MEMORANDUM

DATE: April 3, 2019
TO: Kari Parsons, PCD-Project Manager
FROM: Jeff Rice, PCD-Engineering

SUBJECT: SF-18-021 – Redtail Ranch
Fourth Submittal

CCES Responses

**REDTAIL RANCH FILING NO. 1
CONSTRUCTION DRAWINGS**
STREET SECTIONS / EROSION CONTROL NOTES

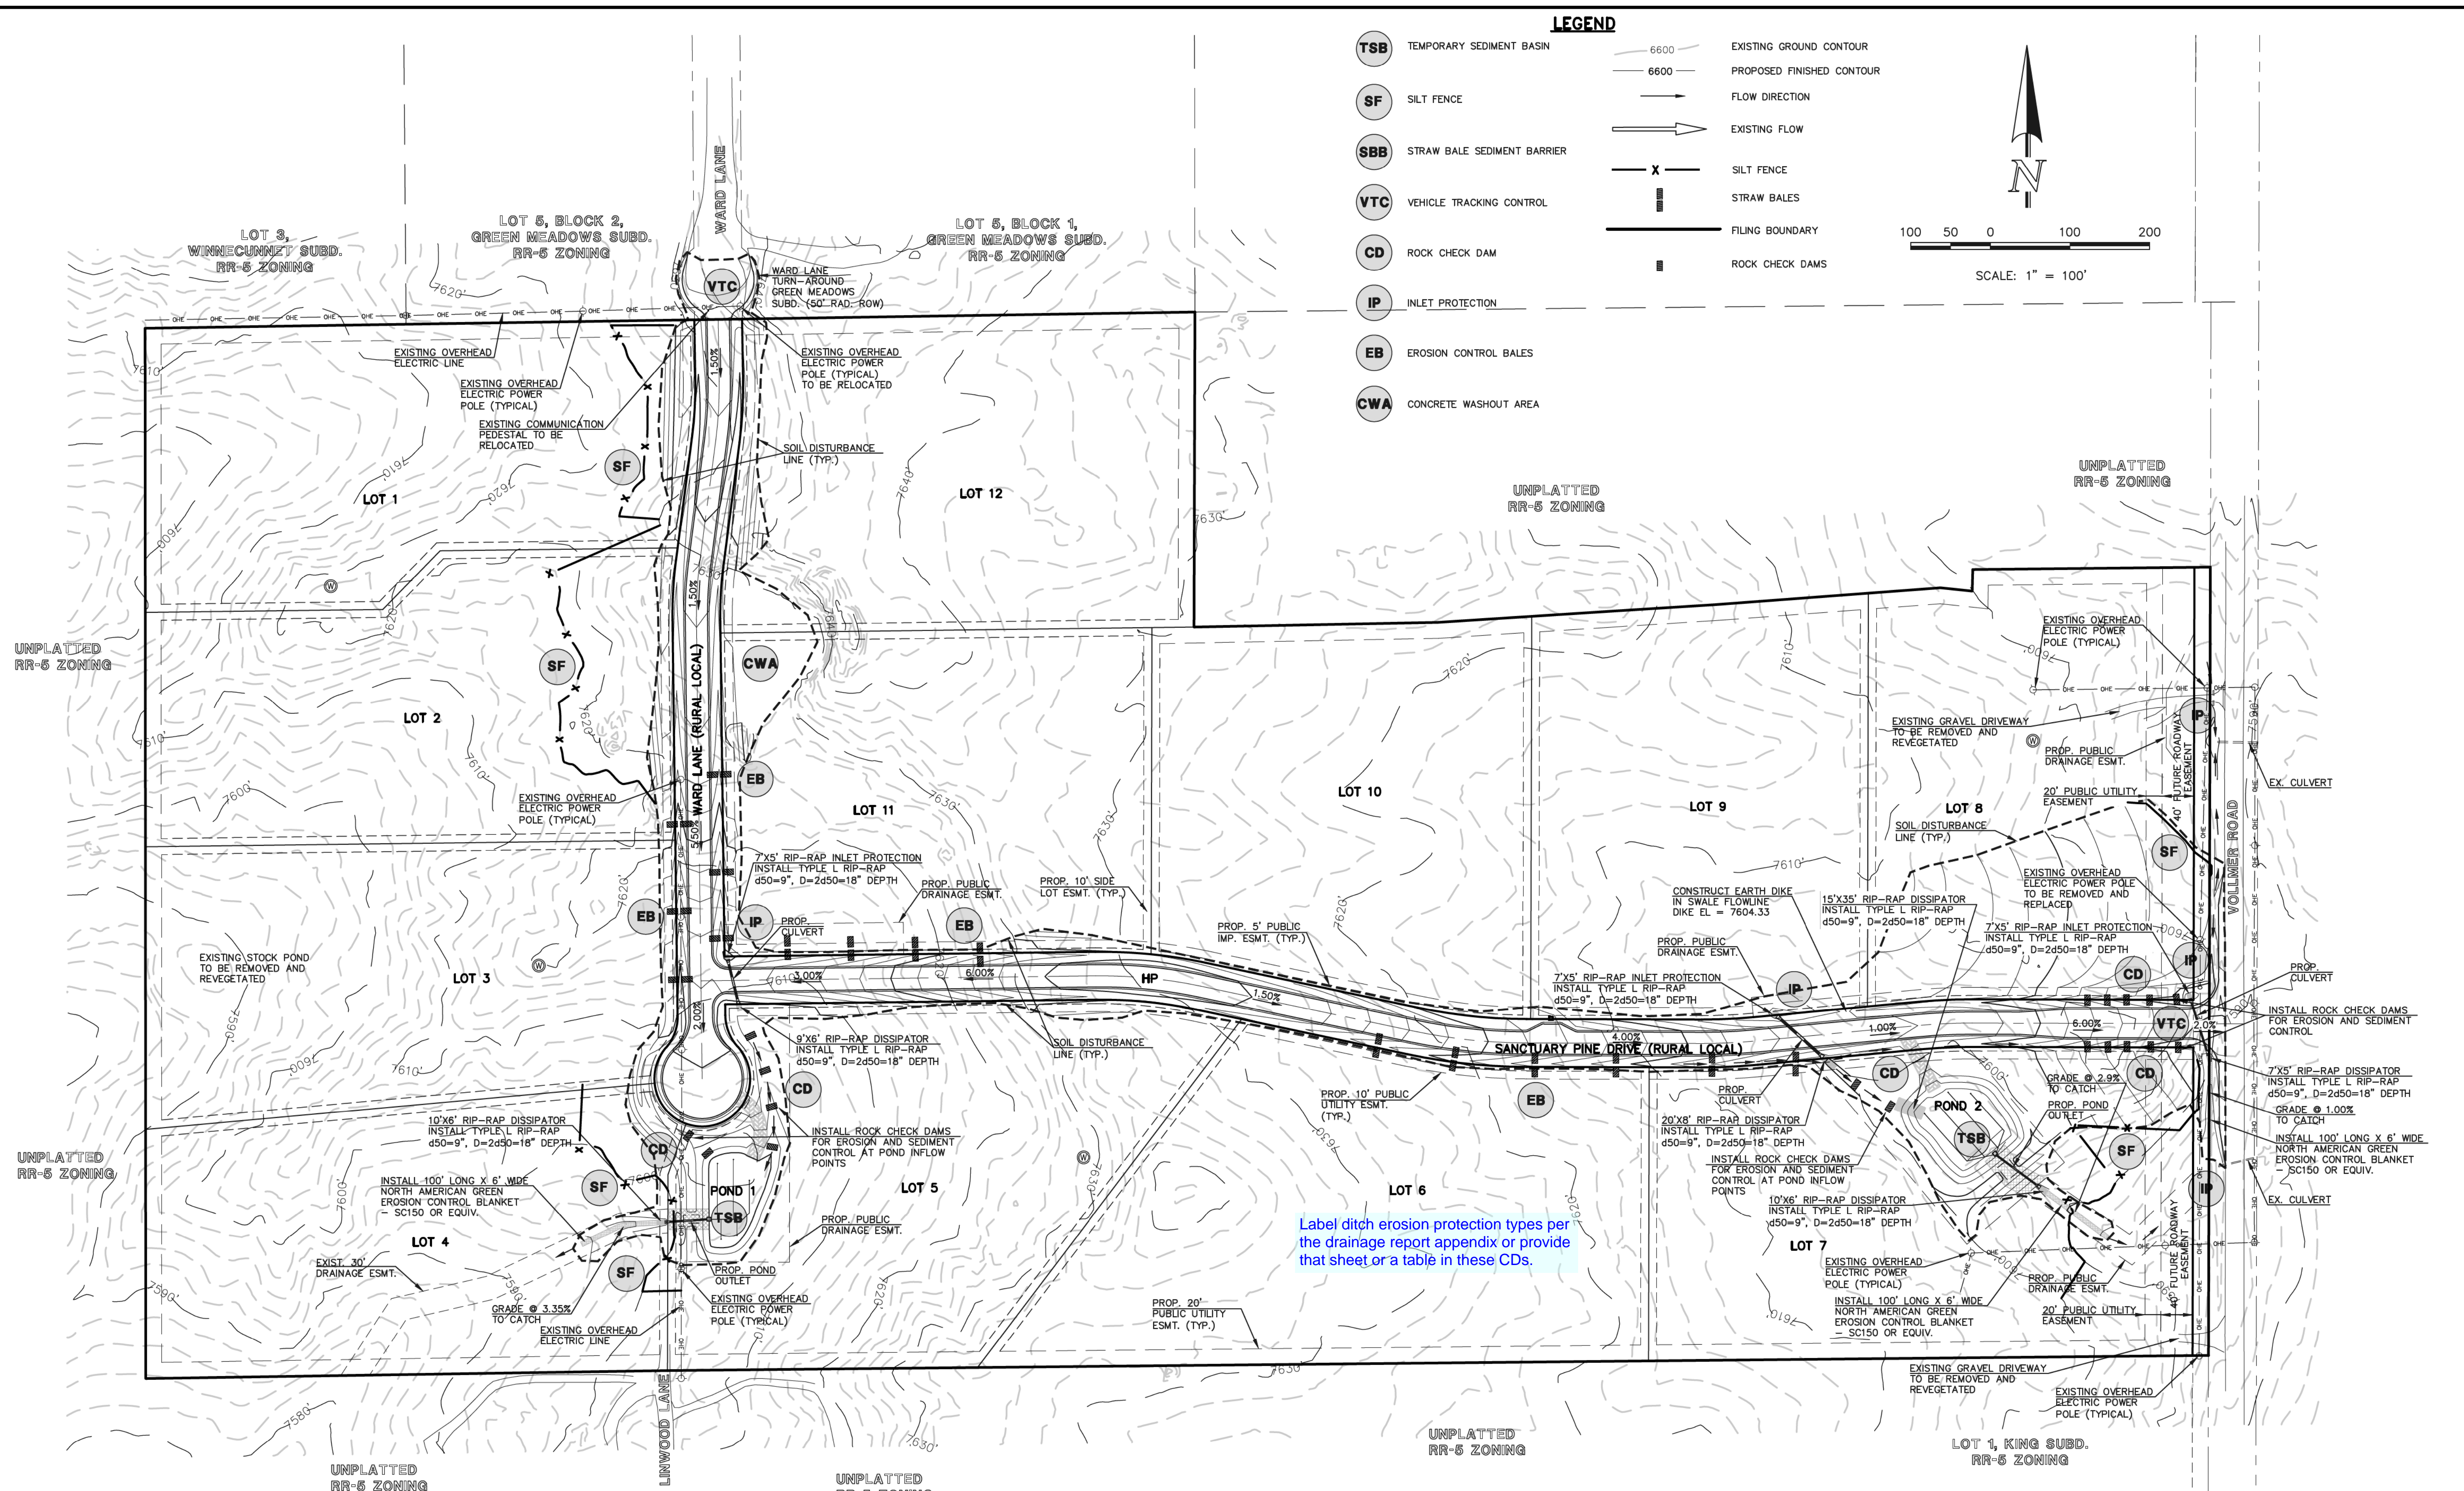
8. See CD redlines for additional comments and clarification of these comments. Partially resolved; see remaining/updated redlines. **See remaining/updated redlines. Addressed comments on sheets 2, 3 and 6 per redlines**

GRADING & EROSION CONTROL PLAN

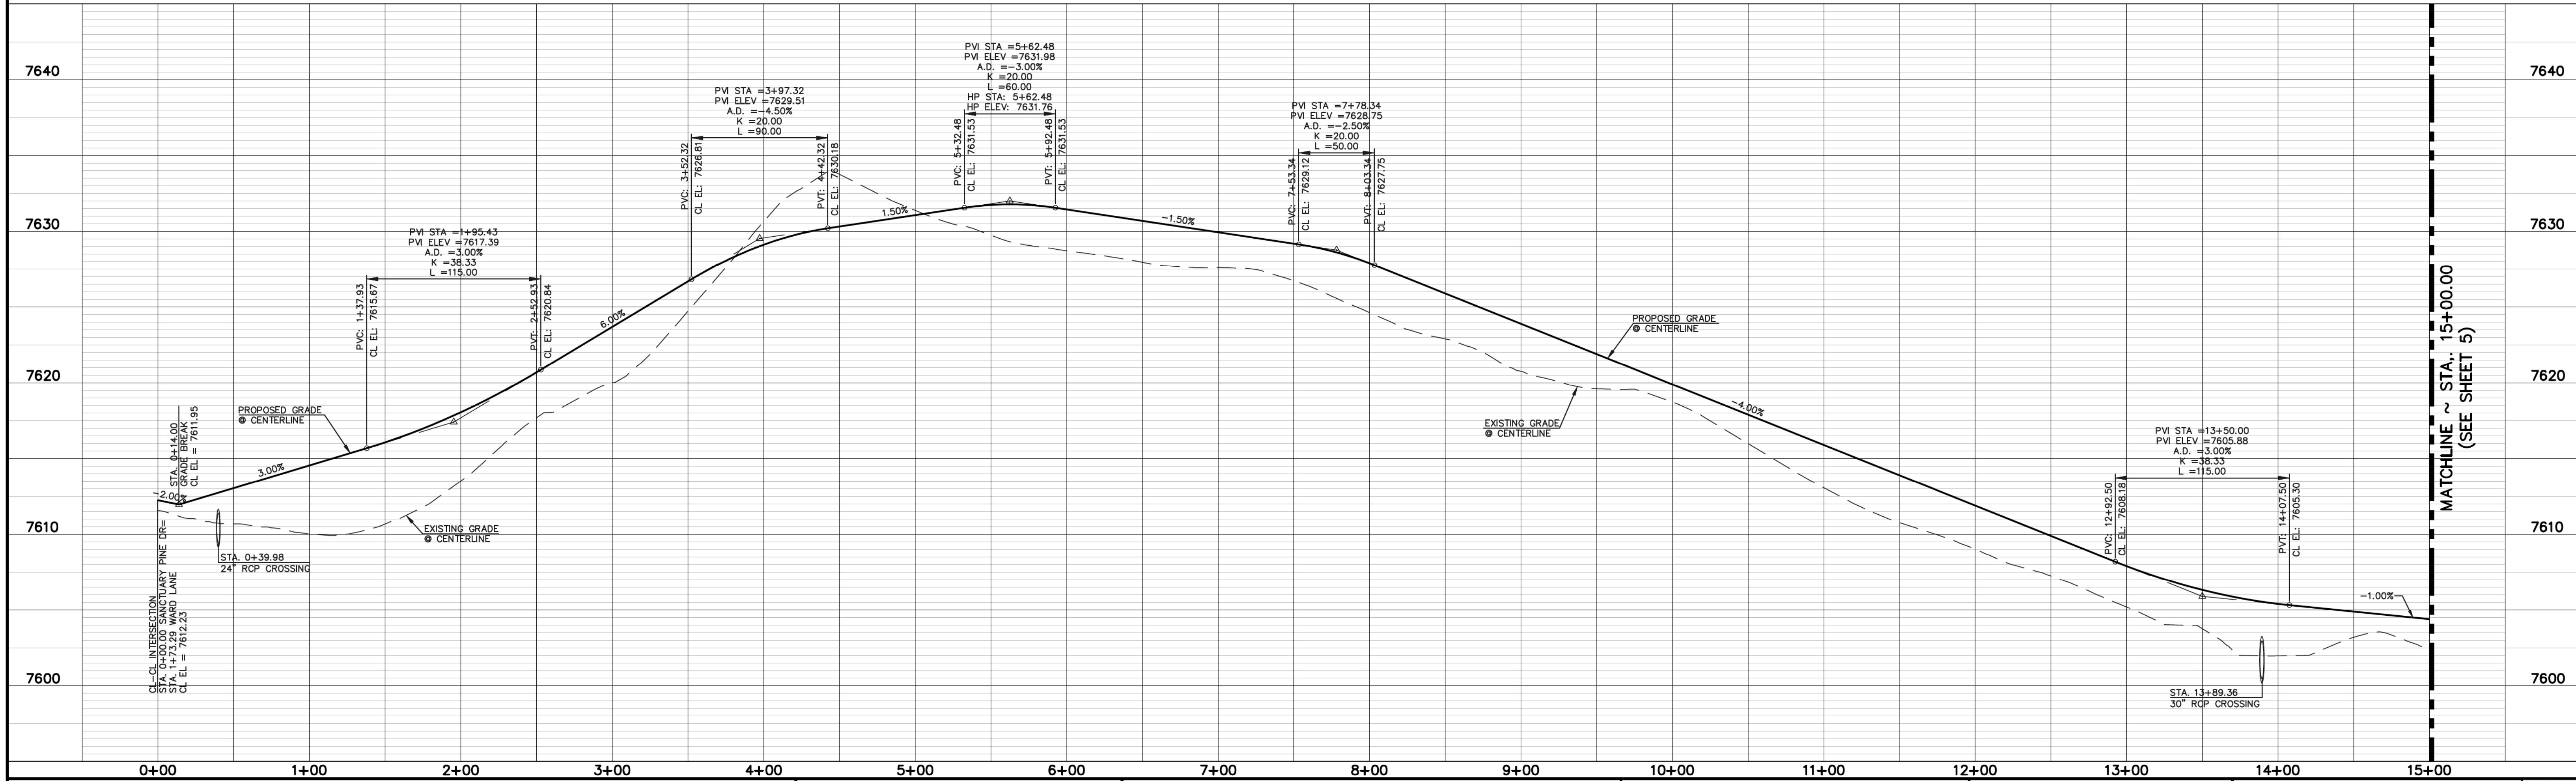
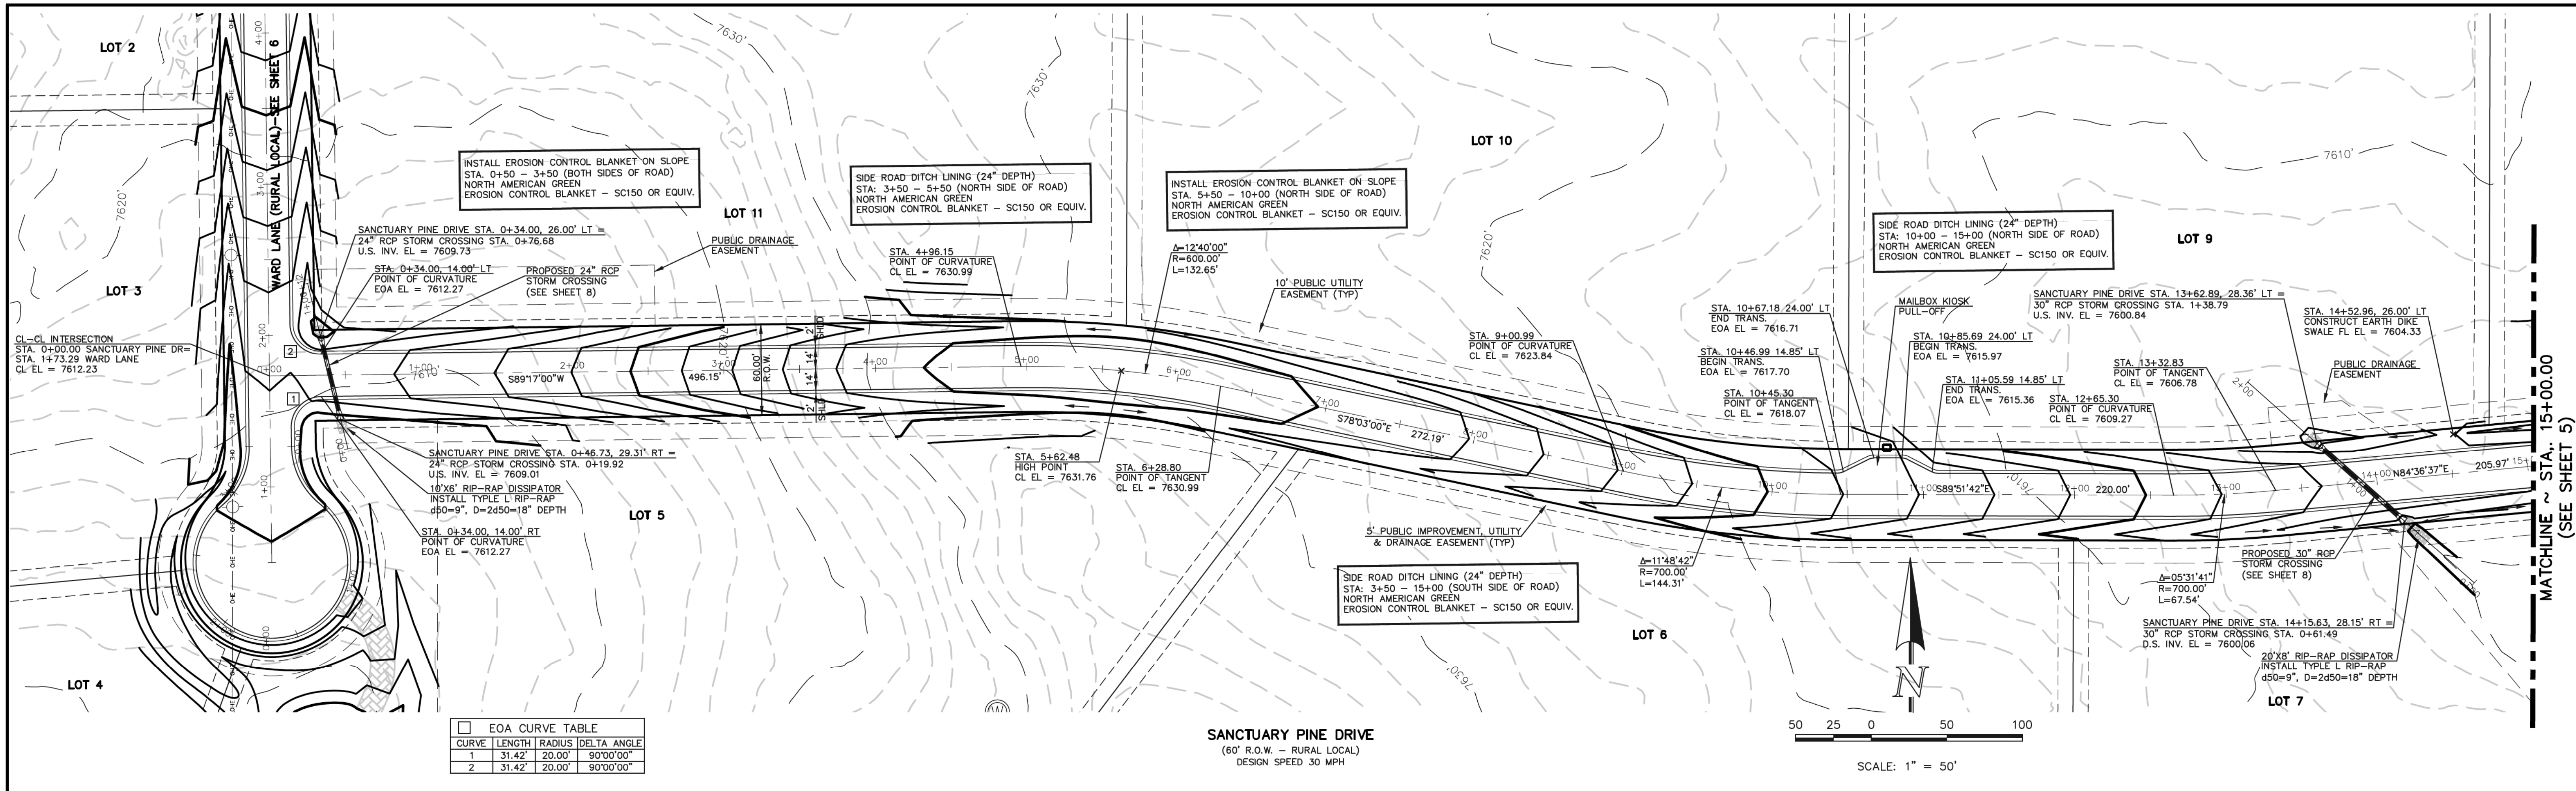
1. Provide sediment basins (temporary and permanent) at all necessary locations. Partially resolved; permanent sediment control is required for the proposed road area (Sanctuary Pine Drive) draining to Vollmer Road without going through Pond 2. Provide BMPs upstream of the proposed Vollmer Road ROW. *Resolved; a license agreement allowing the HOA to maintain the permanent rock check dams within the proposed ROW will be required.*

4. See redlines for additional comments and clarification of these comments. *Partially resolved;*
 - a. See remaining/updated redlines. *See remaining/updated redlines. **See remaining/updated SWMP redlines. Per Jeff, replaced inlet protection with culvert protection detail***
